Application No: M/75/20/PL
Site Address: 13 Elm Drive Elmer Middleton-On-Sea PO22 6JE
Description of works: Demolition of existing dwelling & erection of replacement dwelling. This site is in CIL Zone 4 & is CiL Liable as new dwelling.

Thank you for your internet representation made on 11th November 2020 which has been recorded as an objection with the comments as follows:

DRAWING TITLE
Proposed Floor Plans
PLANNING ISSUE

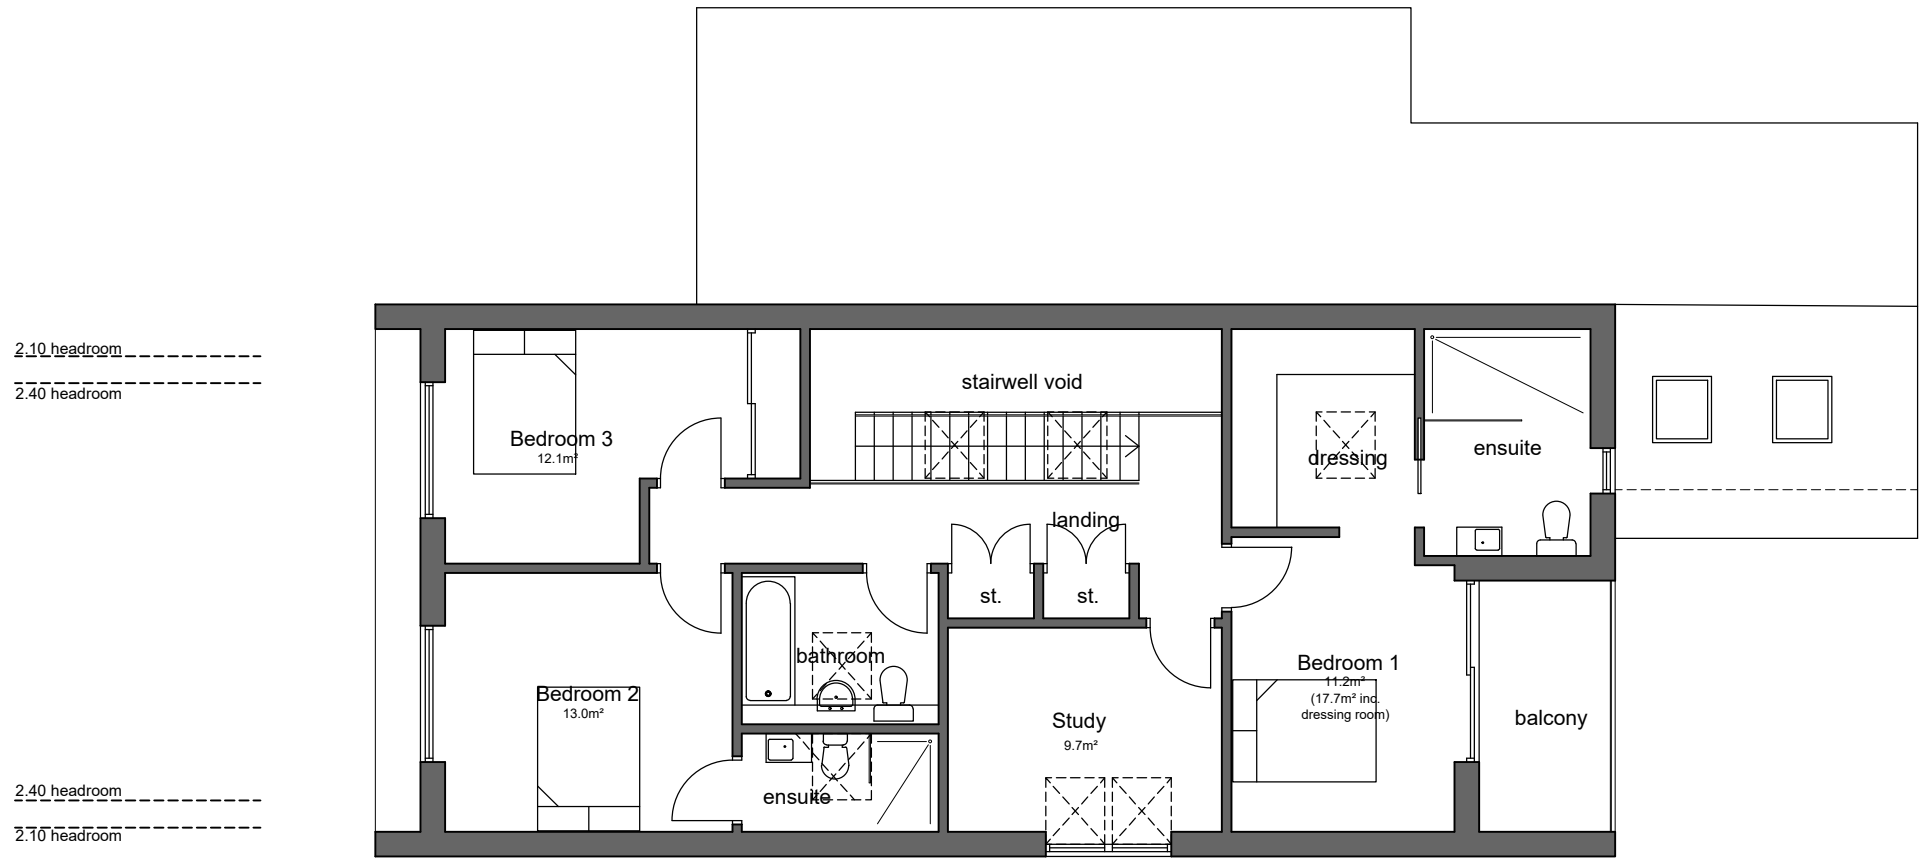
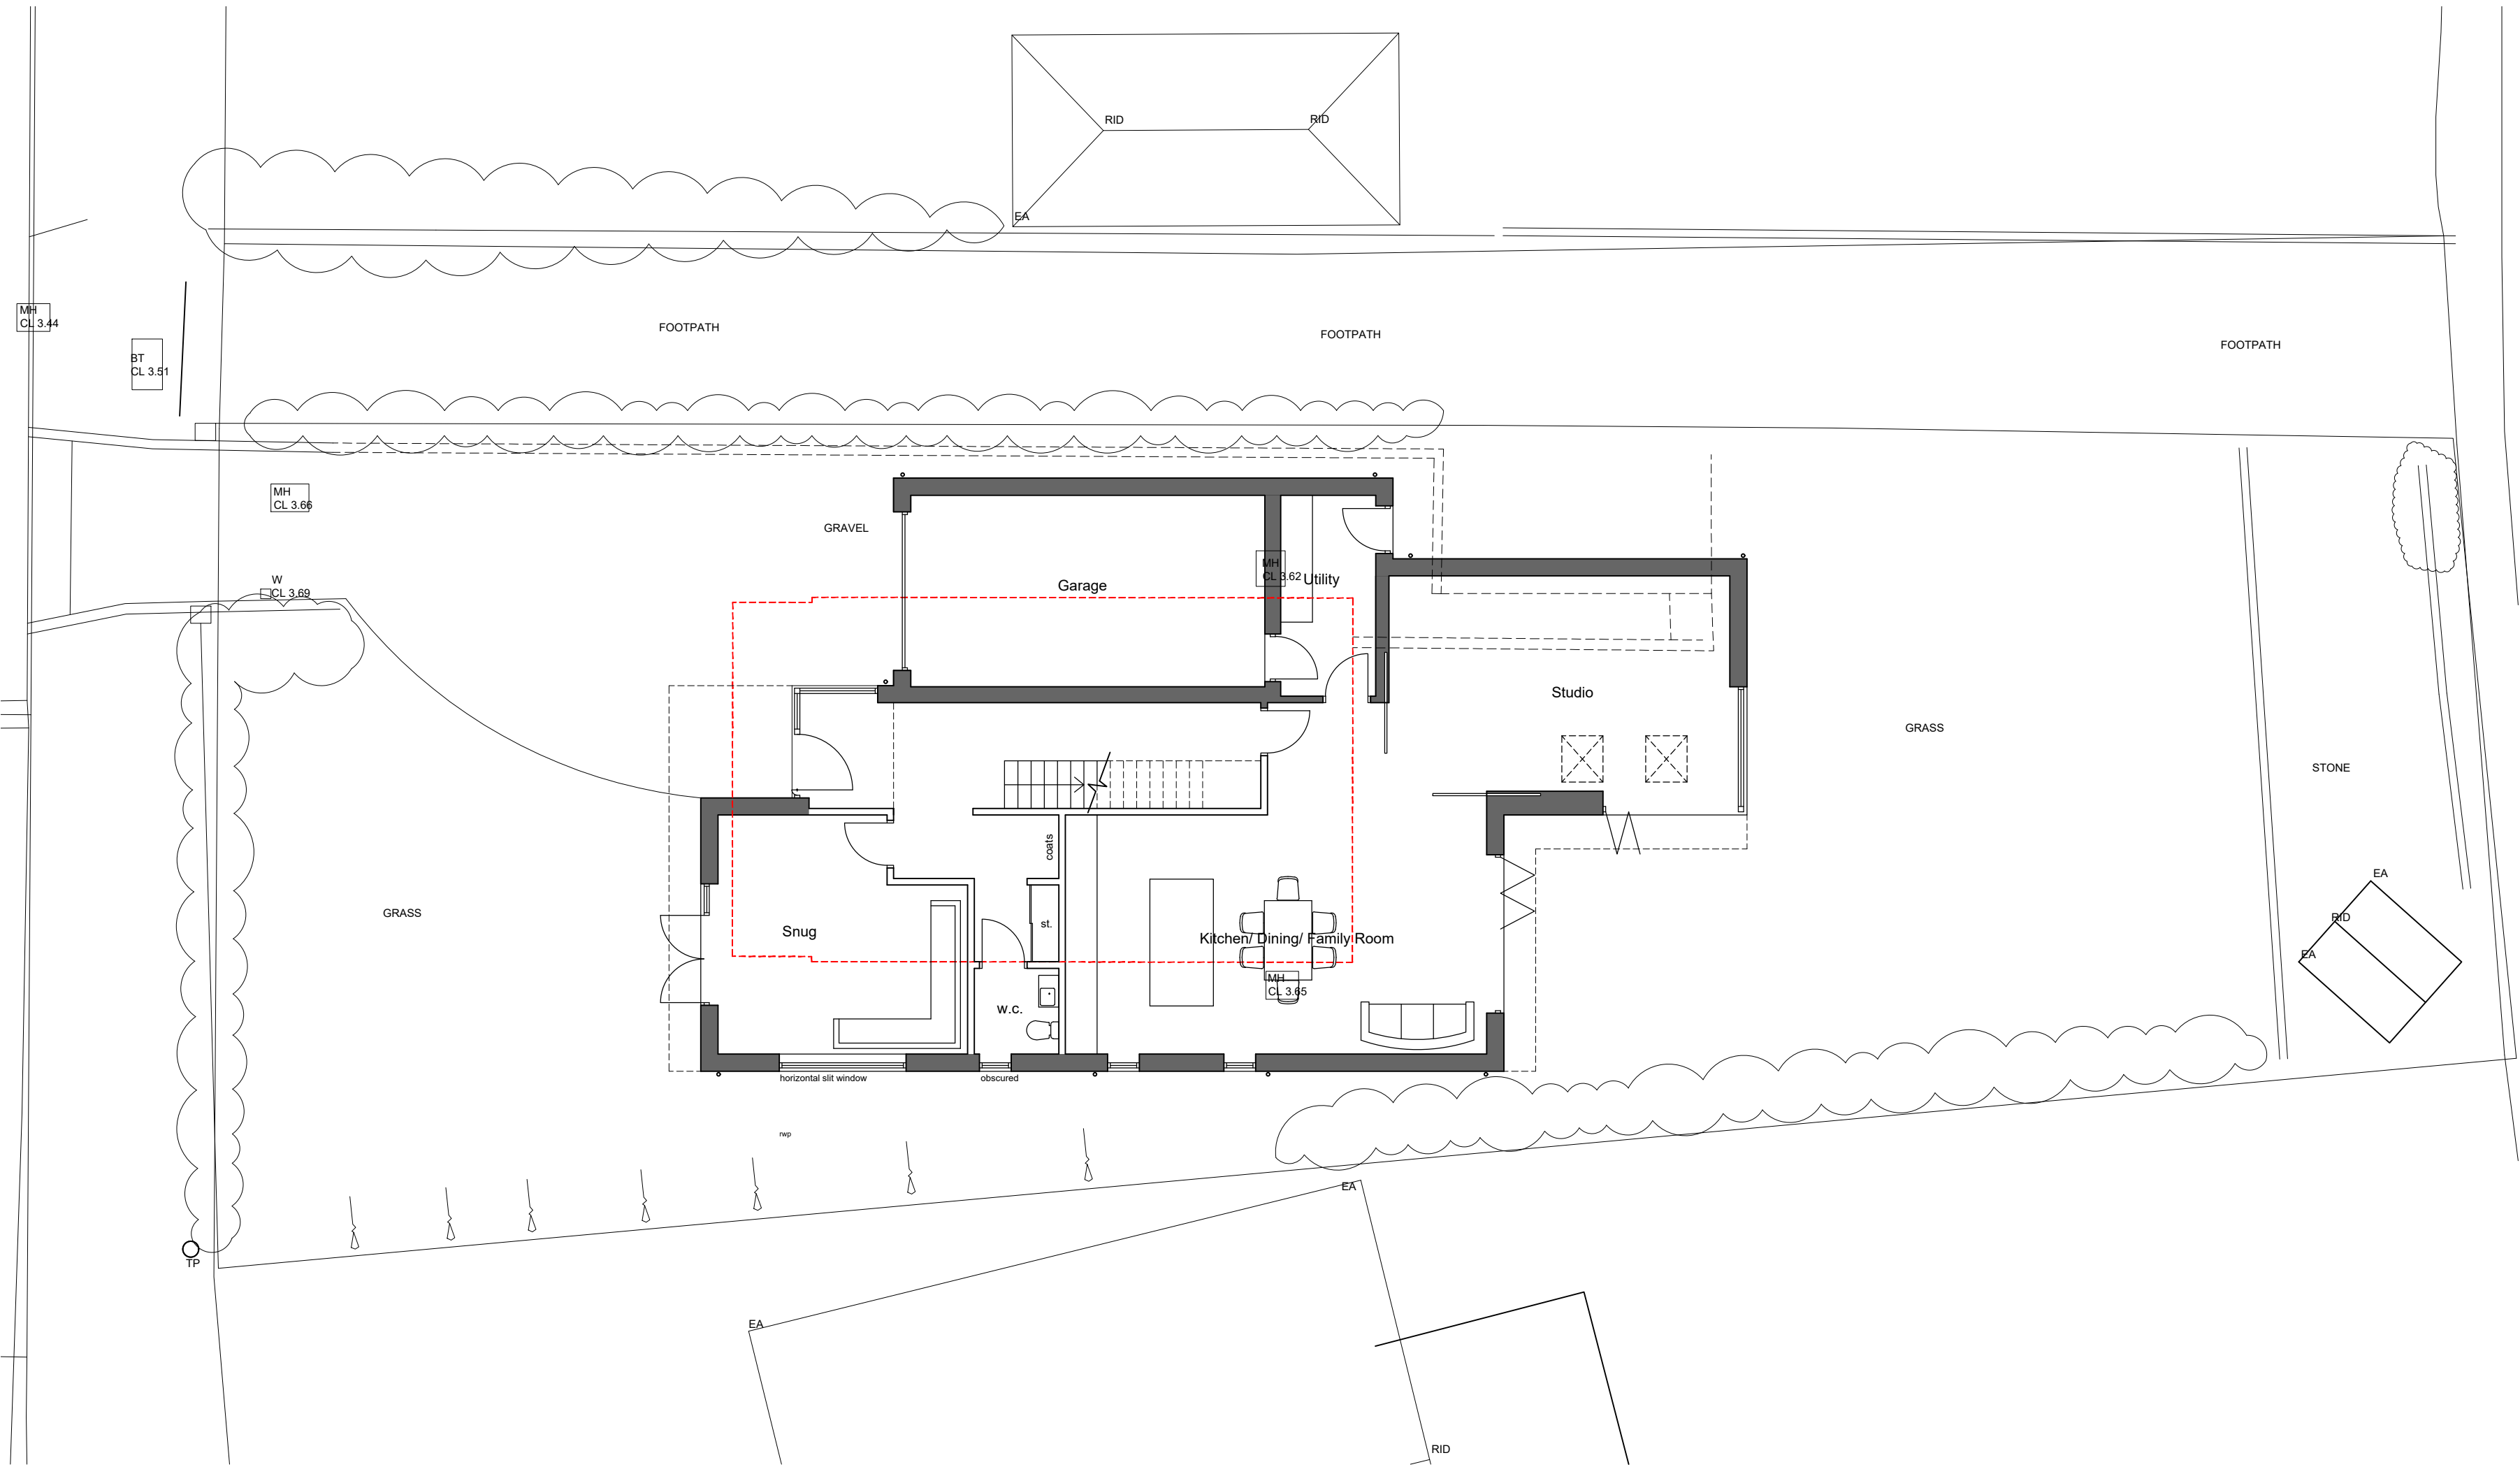
- 2) We are fearful of the room area designated 'studio' proposed at ground floor level. What will it be used for? As this is proposed to be built out towards our property we consider that there should be no windows from it facing east - that is if the extension were approved but which we clearly contend should not be the case.

- 3) The proposed balcony at first floor level - no other property in Elm Drive facing towards Stable Field has a rear balcony. It would directly overlook our bungalow intruding into our lounge and front bedroom
